Ali Mastan
2251 71st Avenue SE
Mercer Island, WA

RE: Permit #2302-151 – Intake Comments - Trees

Intake Comments – March 1, 2023

**PROJECT ARBORIST TREE PROTECTION RECOMMENDATIONS**

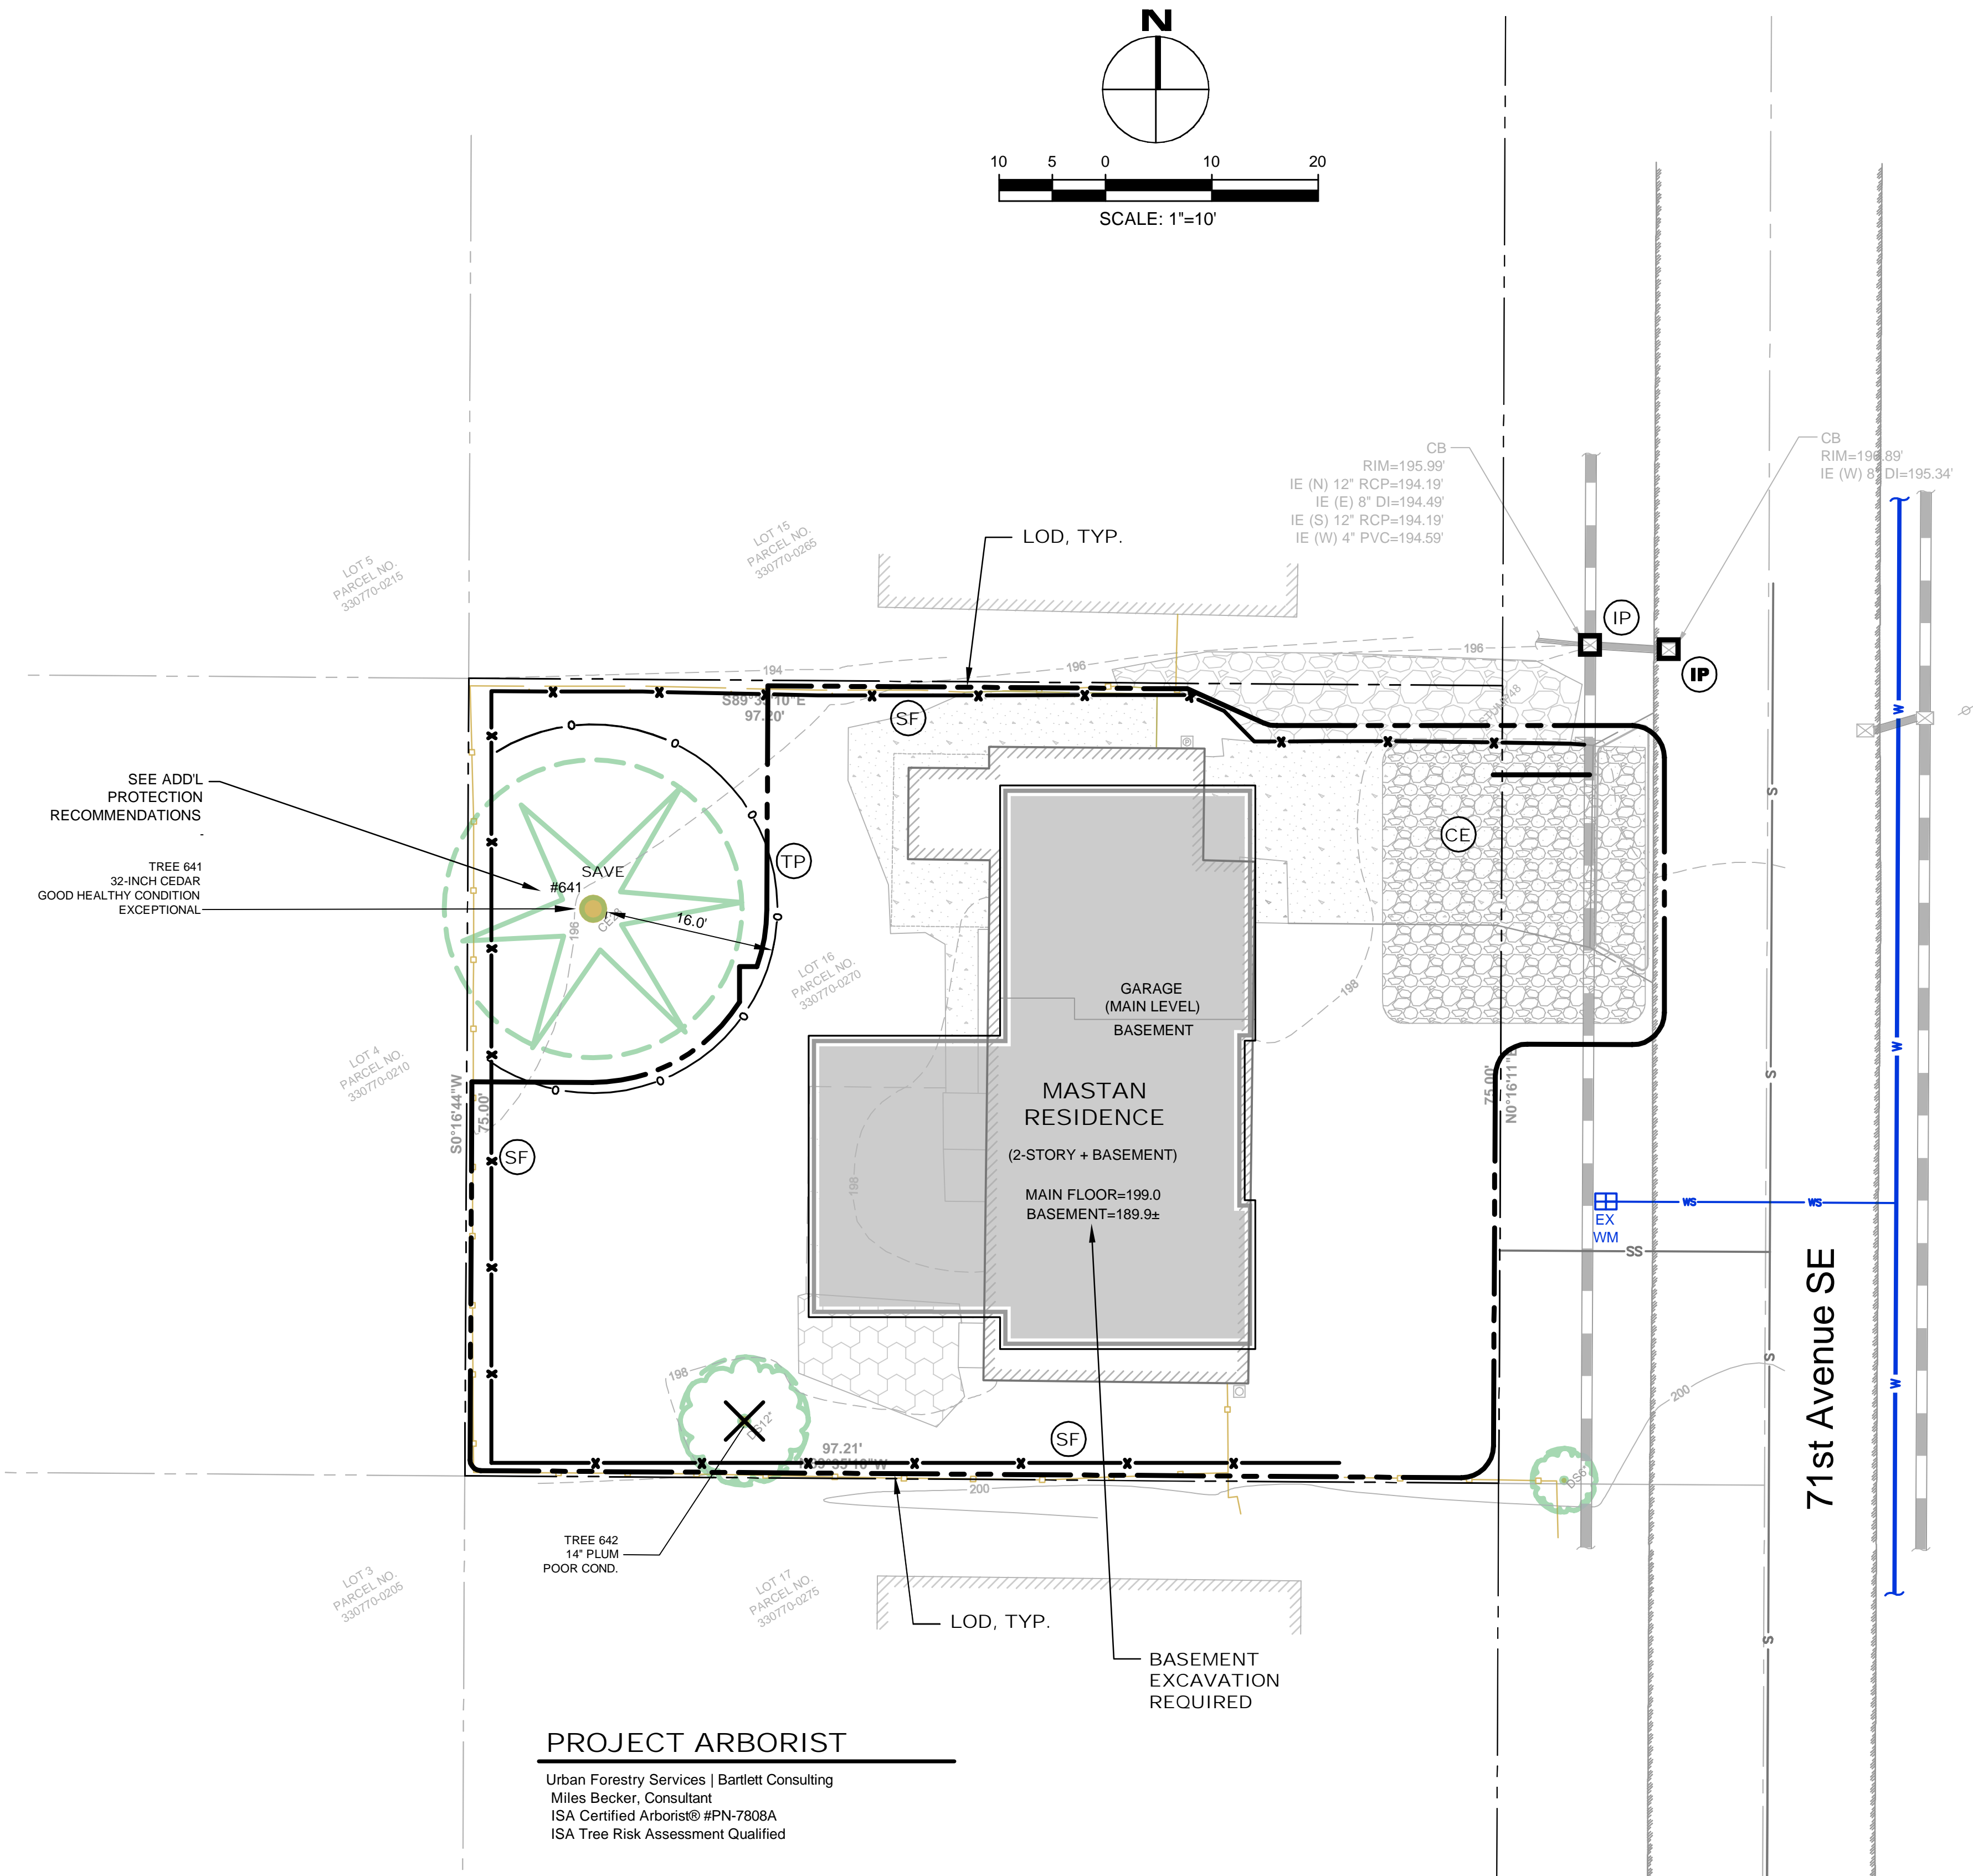
Comment 3: Trees on the Tree Protection Plan in the sheet set should be labeled with the same numbers as in the arborist report.

Comment 4: Tree protection fencing should be at least 16' from the face of the cedar.

Response 3: The two trees on the Plan have been labeled #641 and 642.

Response 4: The fencing location on the Tree Protection Plan and Civil Plan has been moved to a 16-foot radius from the face of the cedar, tree #641.

TREE PLANTING NOTES

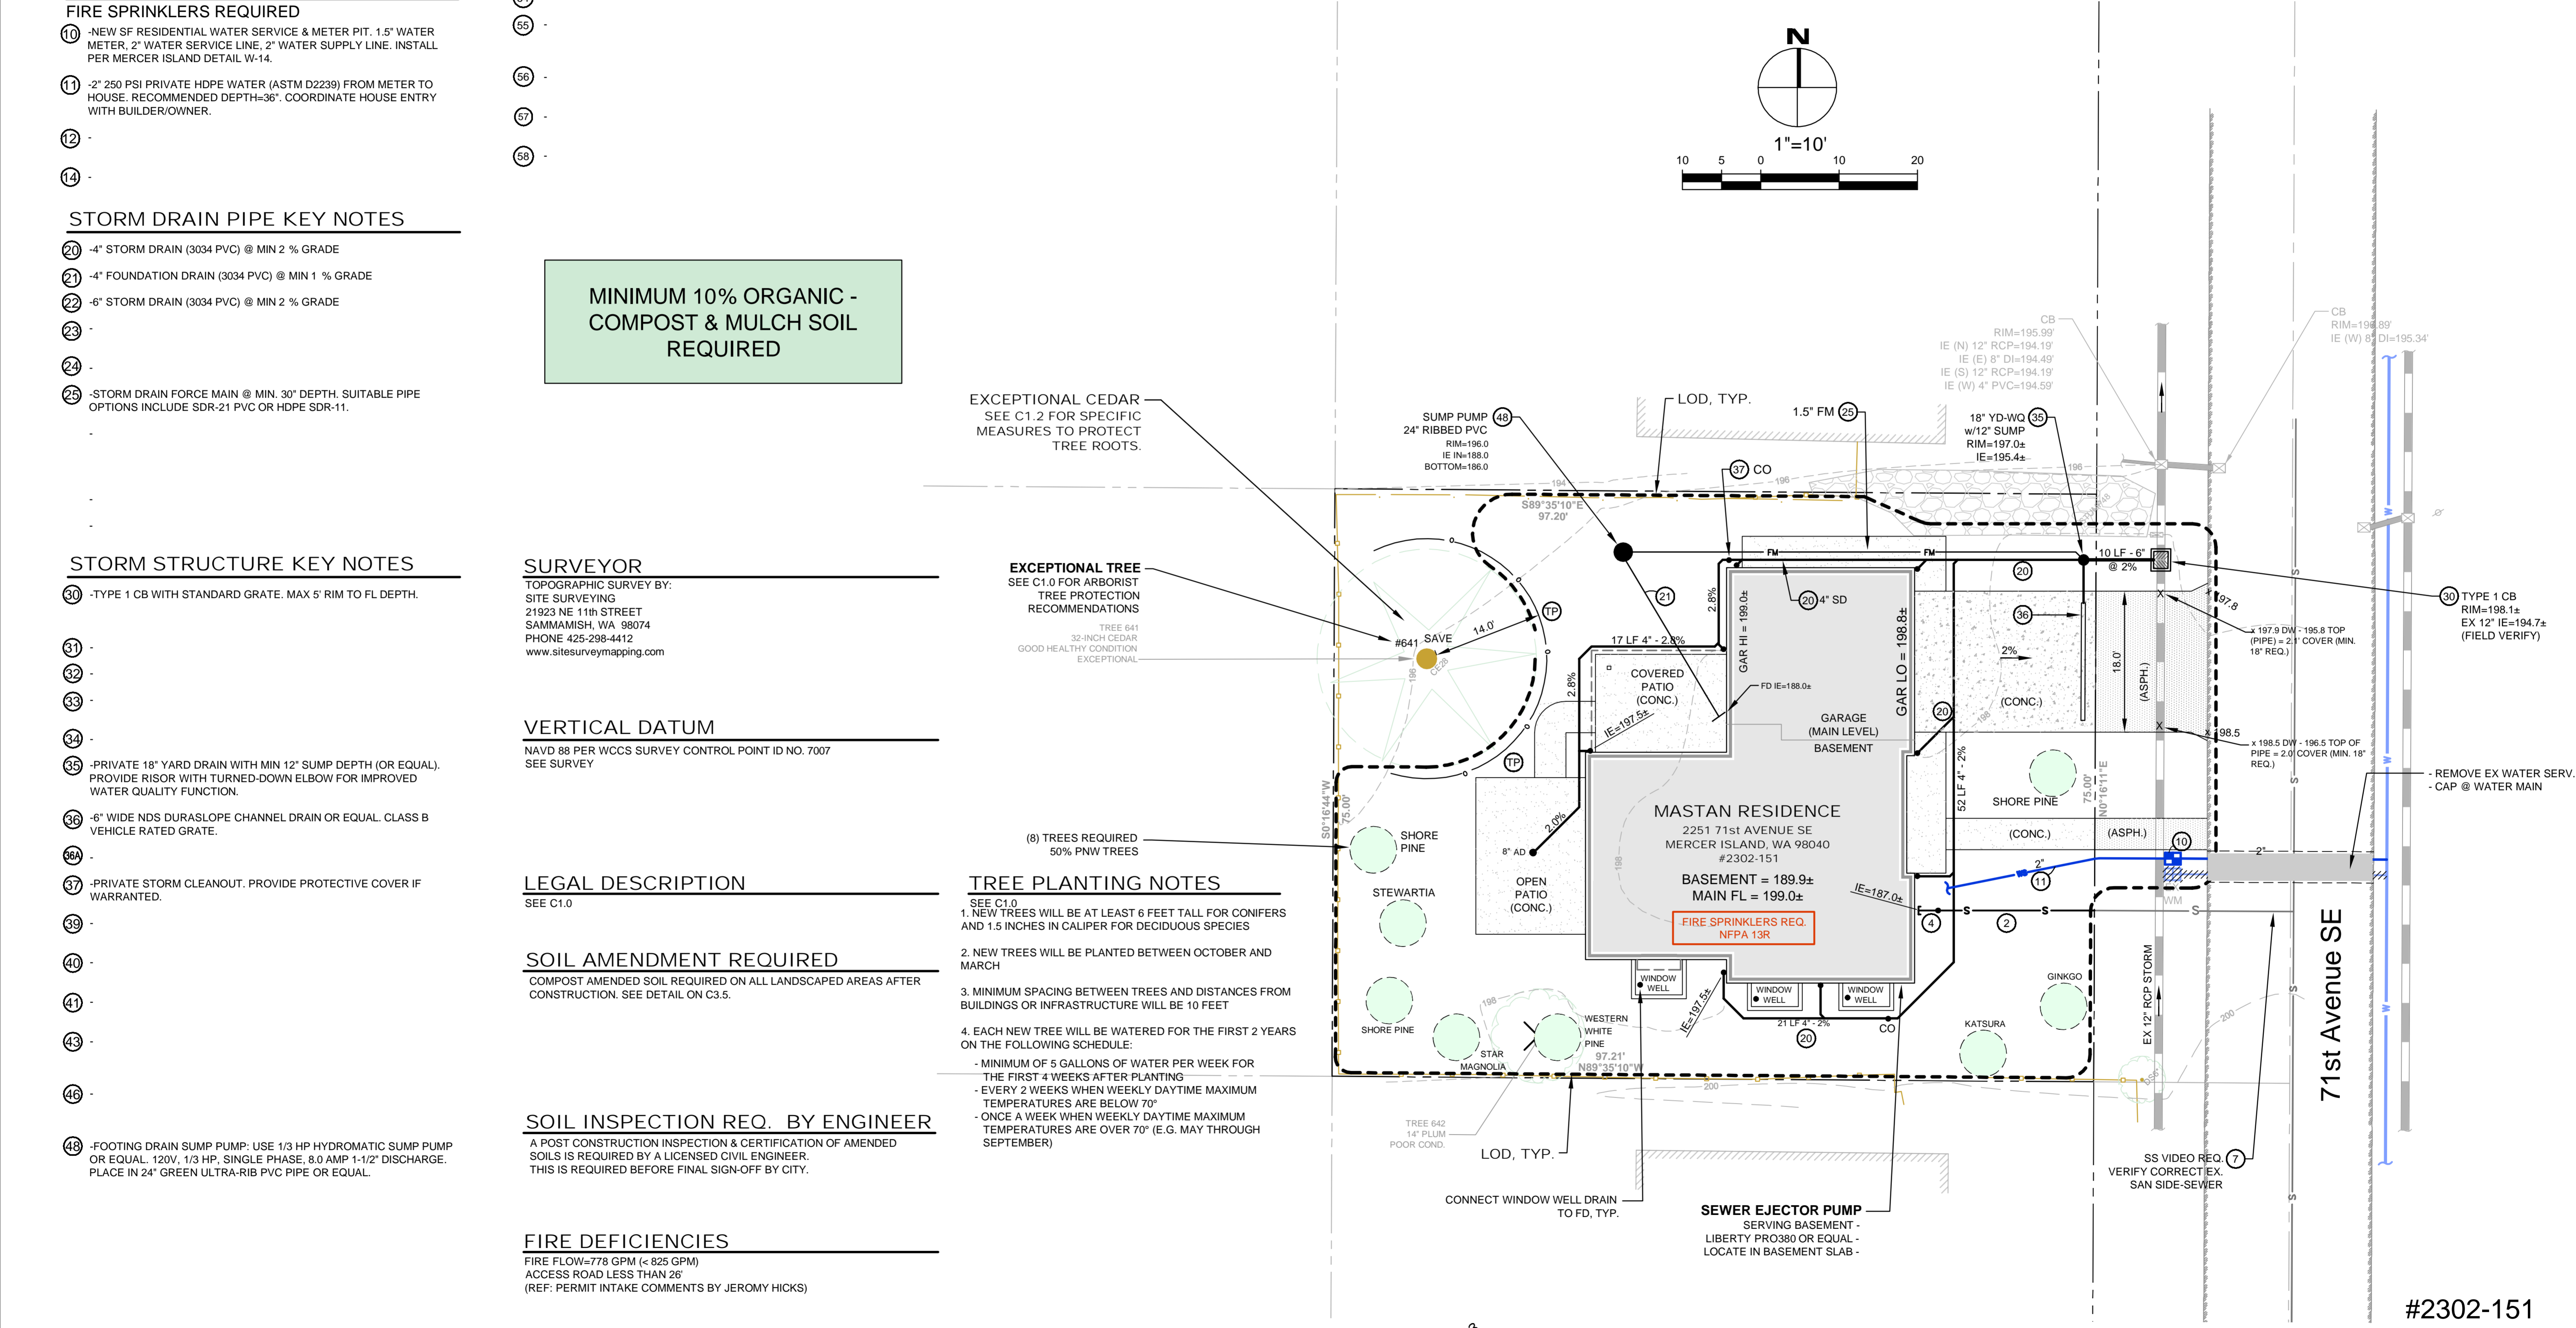
Comment 5: A replanting plan for 7 trees needs to be added to the site plan. Six (6) of these trees are from a previous permit on the property that was closed. One tree is for #642 proposed for removal. At least half the trees need to be PNW native species with a minimum of 10'

spacing. If suitable space is not available for all replanting trees, a request may be made for a fee in lieu of. An irrigation plan is also required to ensure establishment of new plantings.

Response 5: From the tree inventory worksheet, a total of 8 replacement trees are required, 2 for the 14-inch DBH tree #642 proposed for removal. There is sufficient space to plant new trees on the property. The planting locations have been added to the sheet set. Each new planting site is labeled with the tree species. Recommended species to plant are:

Serviceberry (*Amelanchier x grandiflora*) x2
Shore pine (*Pinus contorta*) x1
Western white pine (*Pinus monticola*) x1
Katsura (*Cercidiphyllum japonicum*) x1
Ginkgo (*Ginkgo balboa*) x1
Star magnolia (*Magnolia stellata*) x1
Stewartia (*Stewartia pseudocamellia*) x1

Also added to the sheet set are the specs for successful establishment, including watering:

1. New trees will be at least 6 feet tall for conifers and 1.5 inches in caliper for deciduous species
2. New trees will be planted between October and March
3. Minimum spacing between trees and distances from buildings or infrastructure will be 10'
4. Each new tree will be watered for the first 2 years on the following schedule:
 - minimum of 5 gallons of water per week for the first 4 weeks after planting
 - every 2 weeks when weekly daytime maximum temperatures are below 70°
 - once a week when weekly daytime maximum temperatures are over 70° (e.g. May through September)
